Re: SSD 10399 — Clunies Ross Street, Prospect
Response to Blacktown City Council & Cumberland City Council

Further to your request we are pleased to provide our response to the civil items raised by Blacktown City Council in their information request letter dated 18 September 2020 and Cumberland City Council in their information request letter dated 16 September 2020 (refer enclosed)

STORMWATER QUALITY DEVICE PLAN
 SCALE 1:50

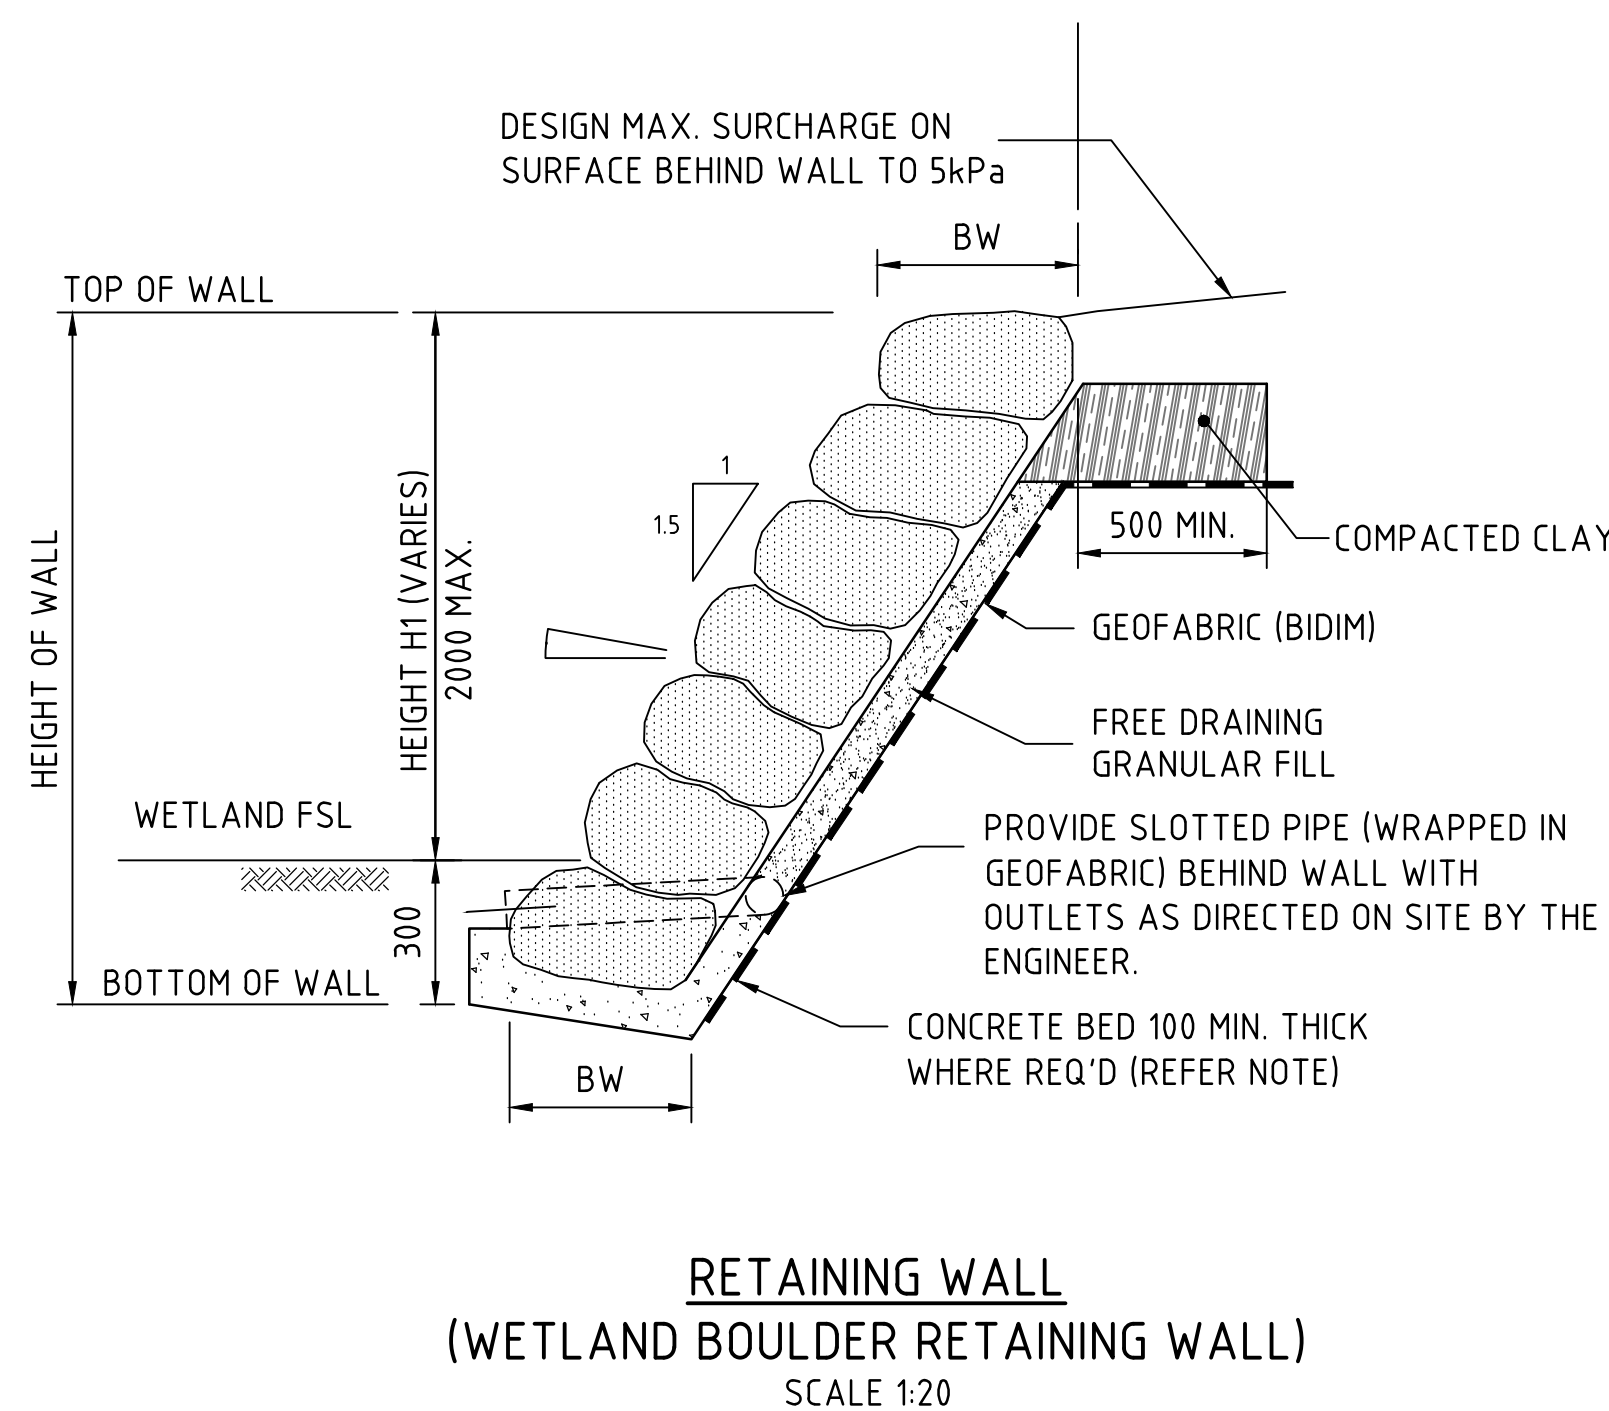
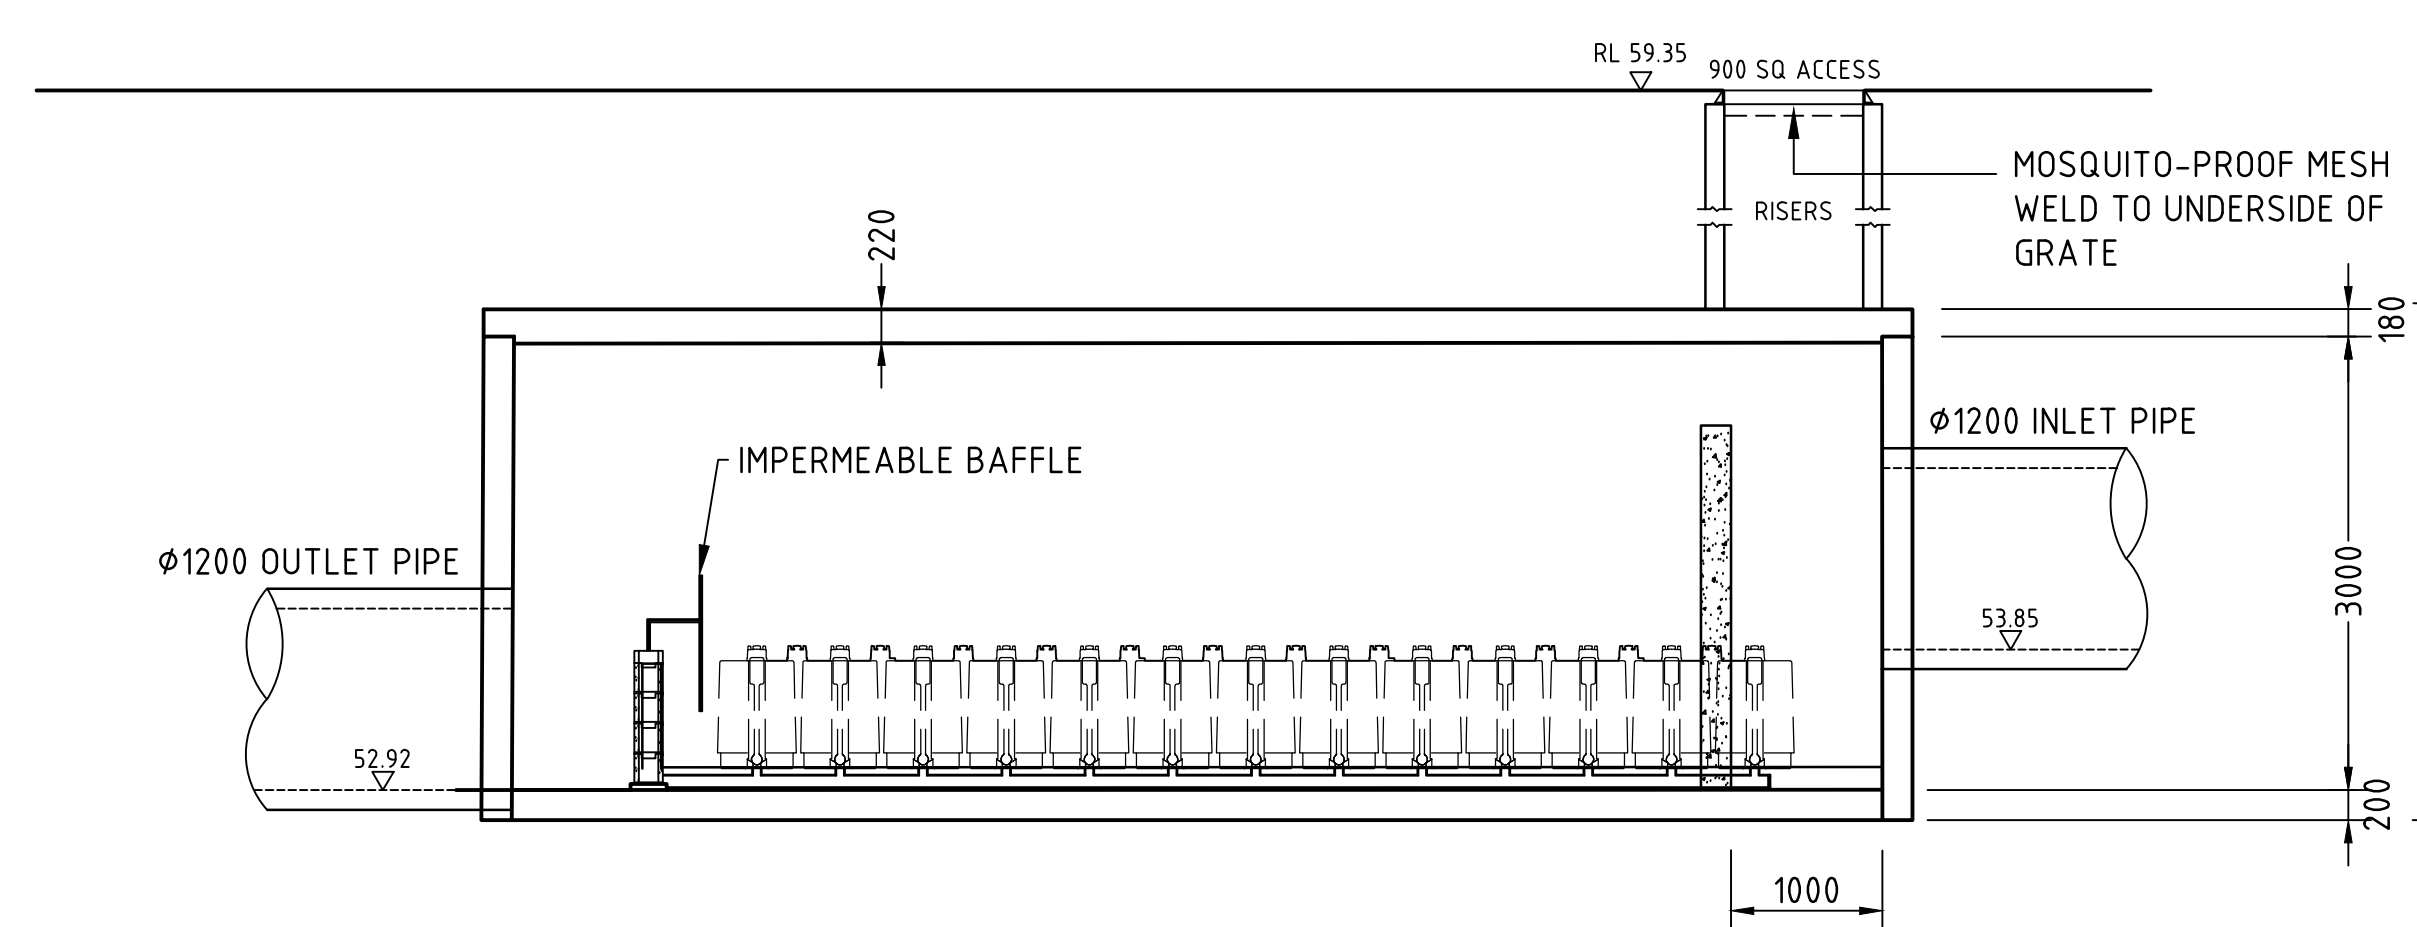
Item 15)	<i>The minimum Stormfilter chamber area is to be No. of Cartridges x 0.177 m2/cartridge excluding the area of the weir.</i> <u>Response</u> Refer to updated drawing Co13251.06-DA45 which confirms details of the stormfilter chamber and typical details including baffles, weirs, chamber area, false floor and other typical information for the chamber.

Item 16)	<i>Ocean Protect has advised that the maximum storage permitted below the Stormfilter weir to ensure effective operation of the filter cartridges is limited to an equivalent volume derived from 2.0 mm of rainfall (20 m3/Ha) without losses, falling over the site area that drains to the Stormfilter chamber (ignoring any bypass area).</i> <u>Response</u> Refer to updated drawing Co13251.06-DA45 which confirms details of the stormfilter chamber and typical details including baffles, weirs, chamber area, false floor and other typical information for the chamber.

No.	Item and Response
	xvi. Noted – additional sections and details on the stormfilter system have been included in updated drawings.
Cumberland City Council	
Planning - Excavation – Bulk Earthworks
